# Longwood gate, Longwood, Huddersfield

Technical Note

September 2025

Project Proposed Residential development adj 84, Longwood Gate, Longwood  
 Client Mr K Schramm, Ridgemoor, Magdale, Holmfirth HD9 6RB  
 Dwg Title (24311)12\_Scheme as proposed\_Elevations  
 Scale 1: 100, 200 @ A1  
 Date Apr 25

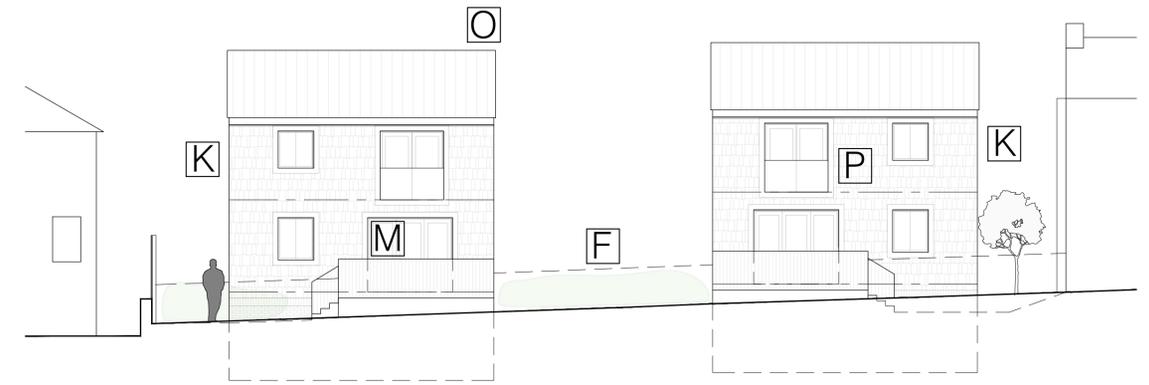
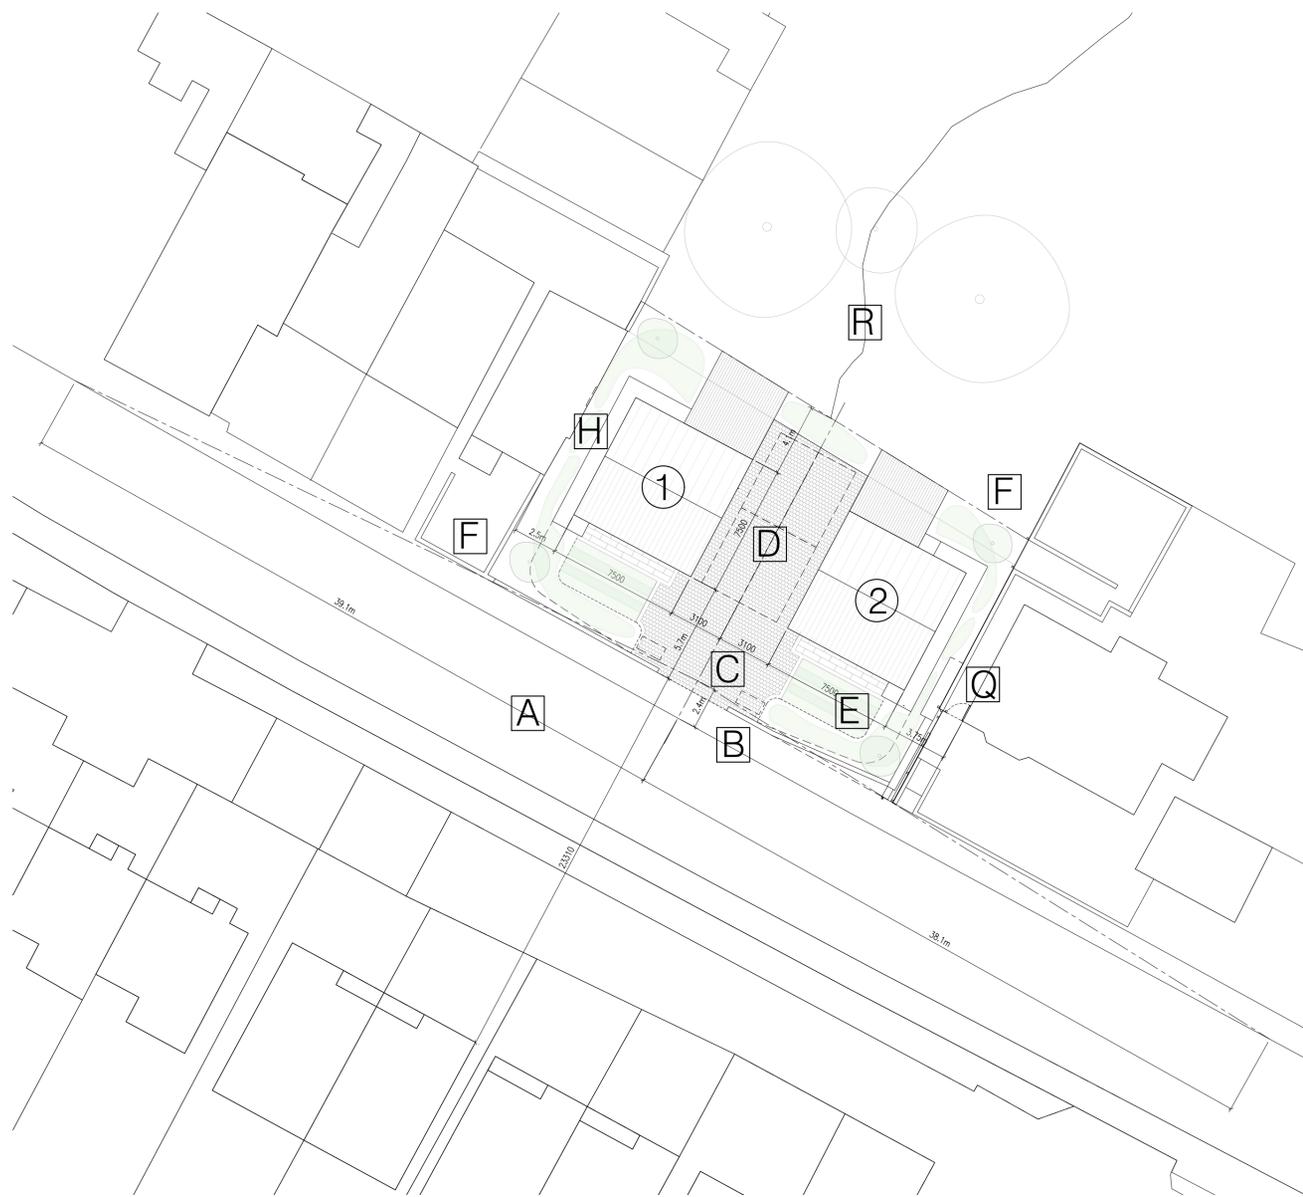
- *There is reference to 'Low level stone wall to match existing with opening onto highway providing visibility splays as Highway engineer detail' on drawing (24311)12\_Scheme as proposed Elevations rev C. Can this detail be provided as it does not appear to be confirmed in any of the other submitted plans / documents.*
- *Visibility is sub standard for a 30 mph road, the submitted plans indicate sightlines of 2.4 x 39.1 and 38.1 respectively. Please can any points considered to be justification of the shortfall of required visibility be set out.*
- *No swept paths to determine if vehicles can enter and exit the site in forward gear have been provided, please can these be submitted.*

- 2.1 Kirklees Council has raised concerns regarding the visibility splays at the proposed access. The previously submitted drawings indicated visibility splays of 2.4m x 39.1m and 38.1m to the nearside kerb line respectively, which were considered substandard against the requirement for a 30mph road. Manual for Streets (MfS) guidance sets the desirable minimum 'Y' distance at 43.0m for a 30mph road.

- 2.2 A further assessment has been undertaken and demonstrates that 2.4m x 43.0m is achievable in both directions when the splays are measured to the nearside wheel track rather than to the kerb line. Section 10.5.3 of Manual for Streets 2 supports this methodology, stating:

- 2.3 This approach therefore represents a robust and policy compliant assessment. The drawing provided at Appendix A demonstrates the achievable visibility splays of 2.4m x 43.0m, measured 0.5m into the carriageway, which accord with MfS requirements for a 30mph road.

- 2.4 To maintain these sightlines, the proposed boundary wall and any planting or structures within the visibility envelope will be limited to a maximum height of 1.0m above carriageway level. This ensures that the splays remain unobstructed at all times.
